**SUBJECT: BRES2105-0025
BUILDING RESIDENTIAL**

Here are the results of all Inspections located at **573 COACHMAN WAY:**

Top View

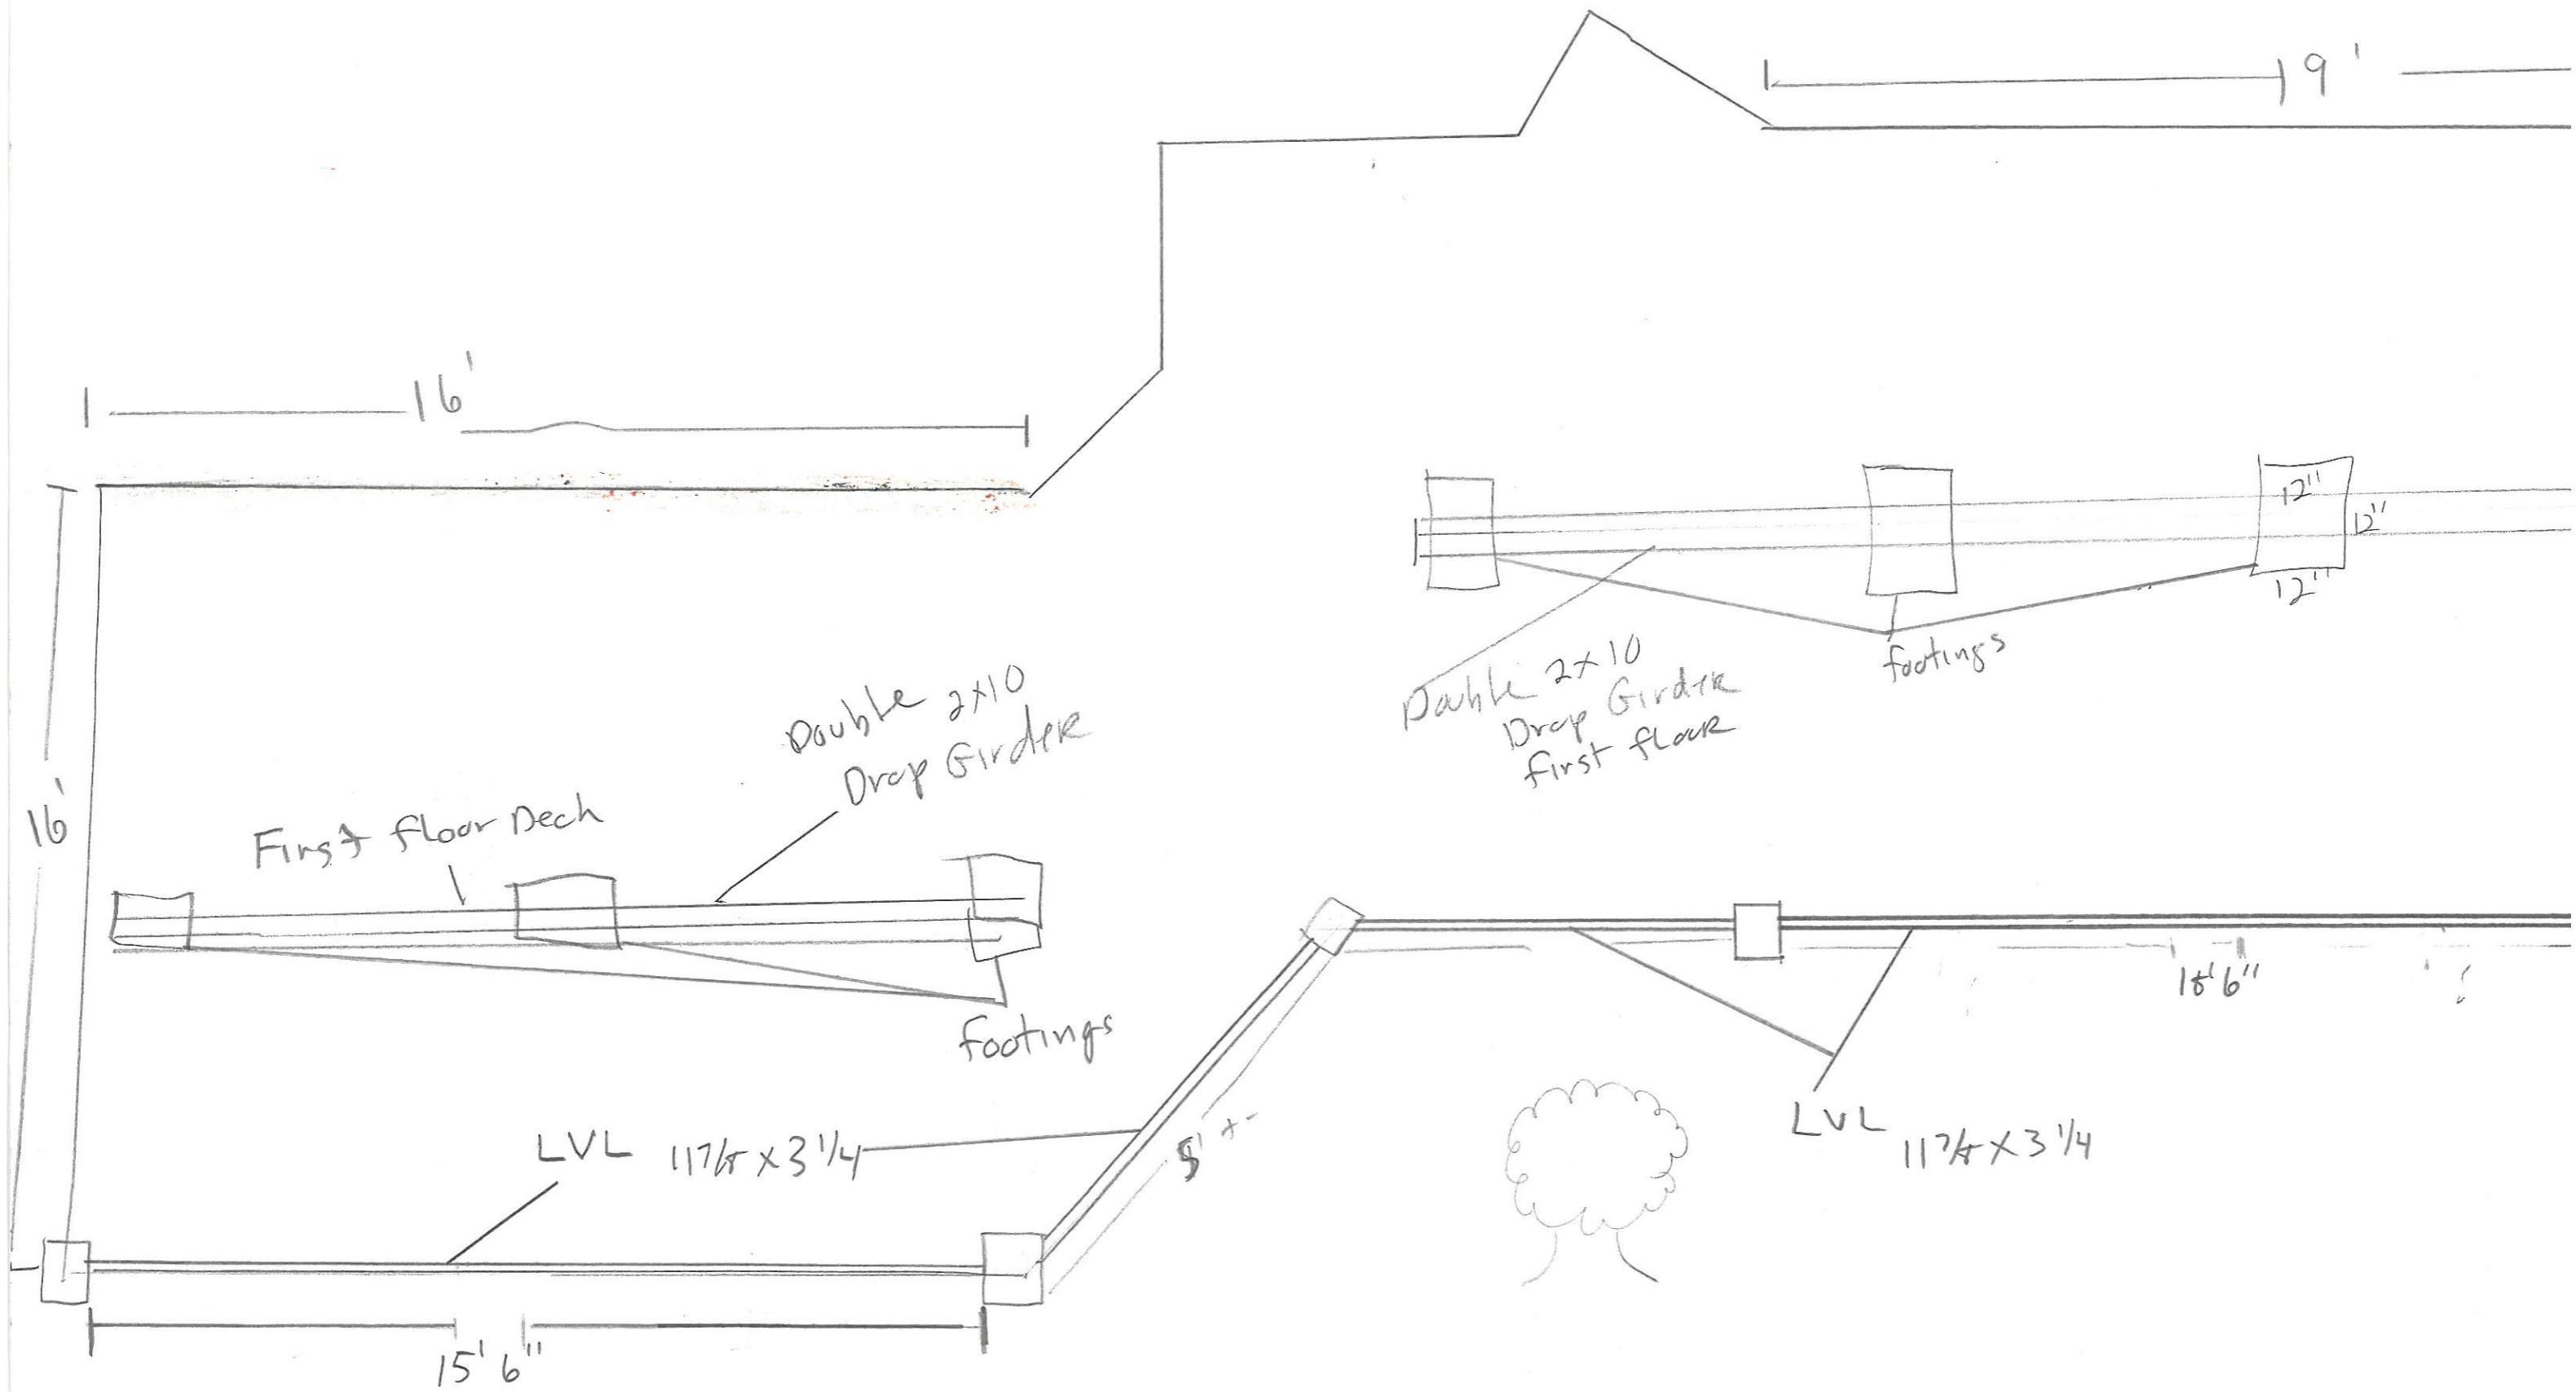
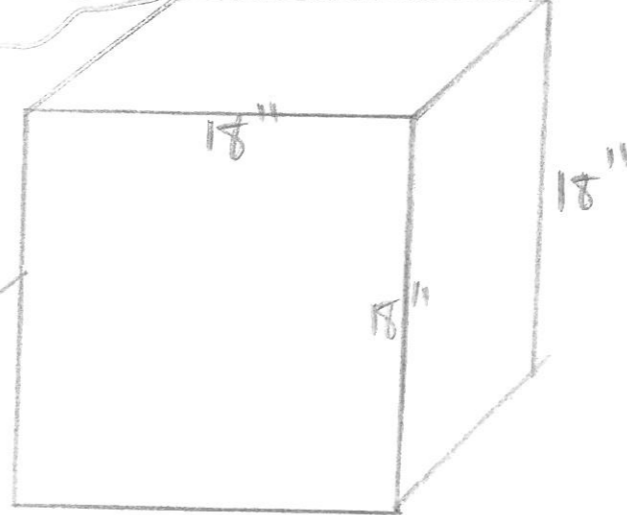
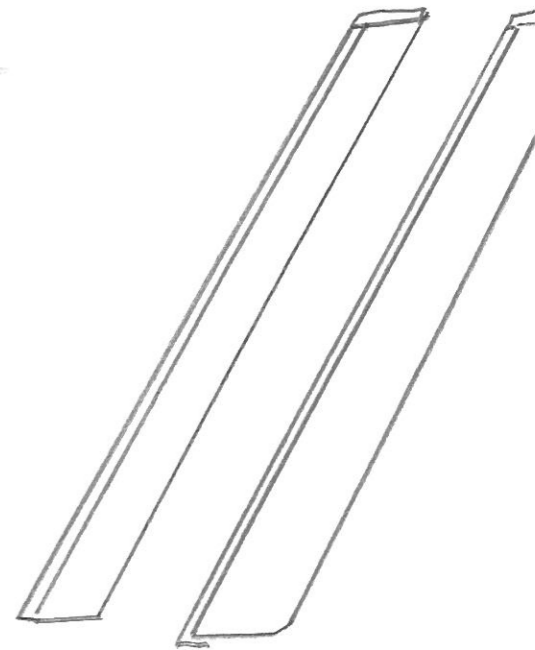
Provide lvi documentation. Handrails must be 34-38 measured at walkline. Provide engineering letter on over span girders and girder splice not bearing on posts, joists exceeding span, girders not supported on posts. Need 3 nails in ledger strip at joist location. Bottom steps cannot exceed the height of steps above.
